From: Nicola Swann 
Sent: 12 September 2019 13:42
To: Planning.Responses <Planning.Responses@arun.gov.uk>
Subject: Pagham responses

Pagham Parish Council have considered the following applications at a meeting of the Planning Committee held on 10th September 2019:

- 6.1** P/75/19/T – 8 Manor Park, Nyetimber PO21 3JS – fell 1NO Monterey Pine (T1). Deadwood and remove cones to 3No. Monterey Pine. Returned to the Committee following a site visit by Cllr Mr Huntley. **RESOLVED:** Cllr Mr Huntley advised that one tree had died and should be removed and the other tree could have the dead wood safely removed but there was no reason to remove the tree itself. There was no need to remove the cones as they would not become detached under normal circumstances. He provided a tree report to the Clerk (copy appended to the minutes). **REPORTS ATTACHED.**

Application Ref **P/ 75/19/T**: - Proposed Tree Works to Monterey Pines at 8 Manor Park Nyetimber Bognor Regis.

PLAN 1

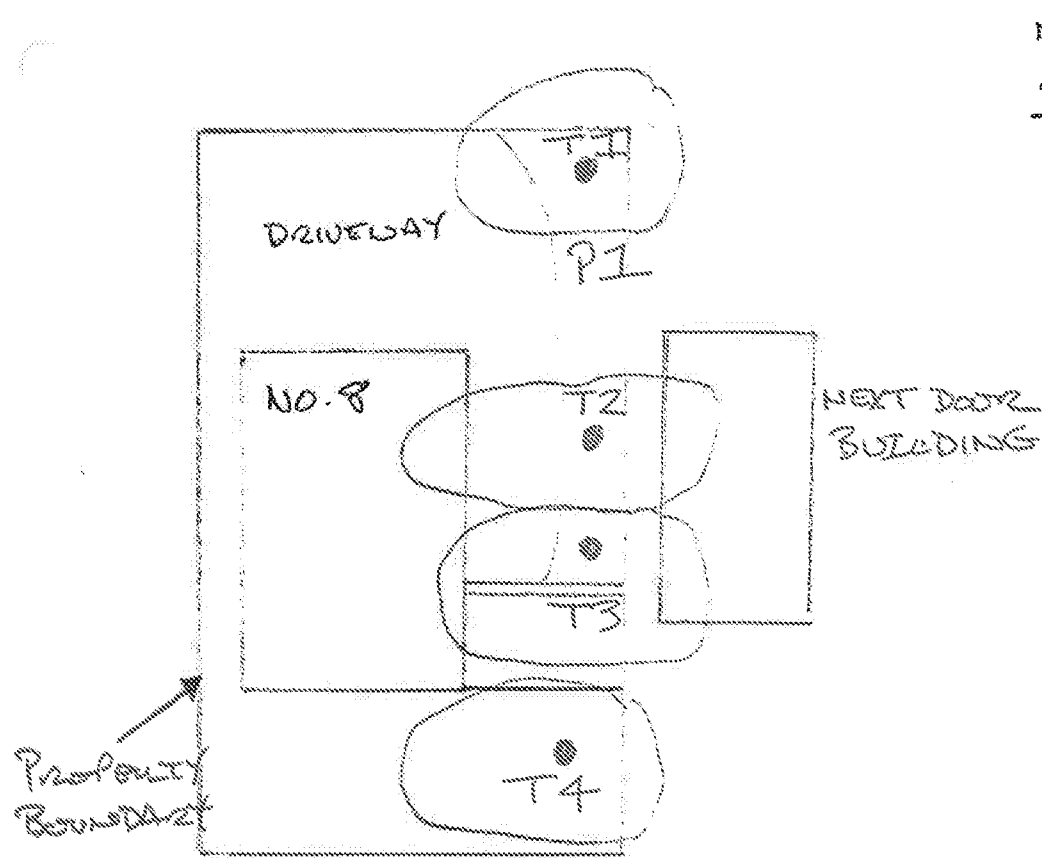
I was asked to inspect these trees for a second time at this address. The trees are growing around the east and south edges of this site. An unnecessarily large proportion of the garden has been covered in hard surfacing topped by gravel; this has damaged the roots of one of these trees to the north of the site evidenced by yellowing foliage and death of lower branches. This tree might as well be removed as it no longer is an amenity asset and is dying.

It is inappropriate to remove cones from a Monterey pine as they stay on the tree for life and only open when the tree is destroyed by fire. They are part of the tree's architecture. Removing the cones would damage the tree. The next paragraph is my original comments which still apply should any further interference with these trees be contemplated (I believe they would do best left alone).

The healthy dark green Monterey Pine trees to the south should be retained as they are an important feature of Nyetimber, East Pagham and Aldwick in general. The ADC tree officer might wish to inspect this site.
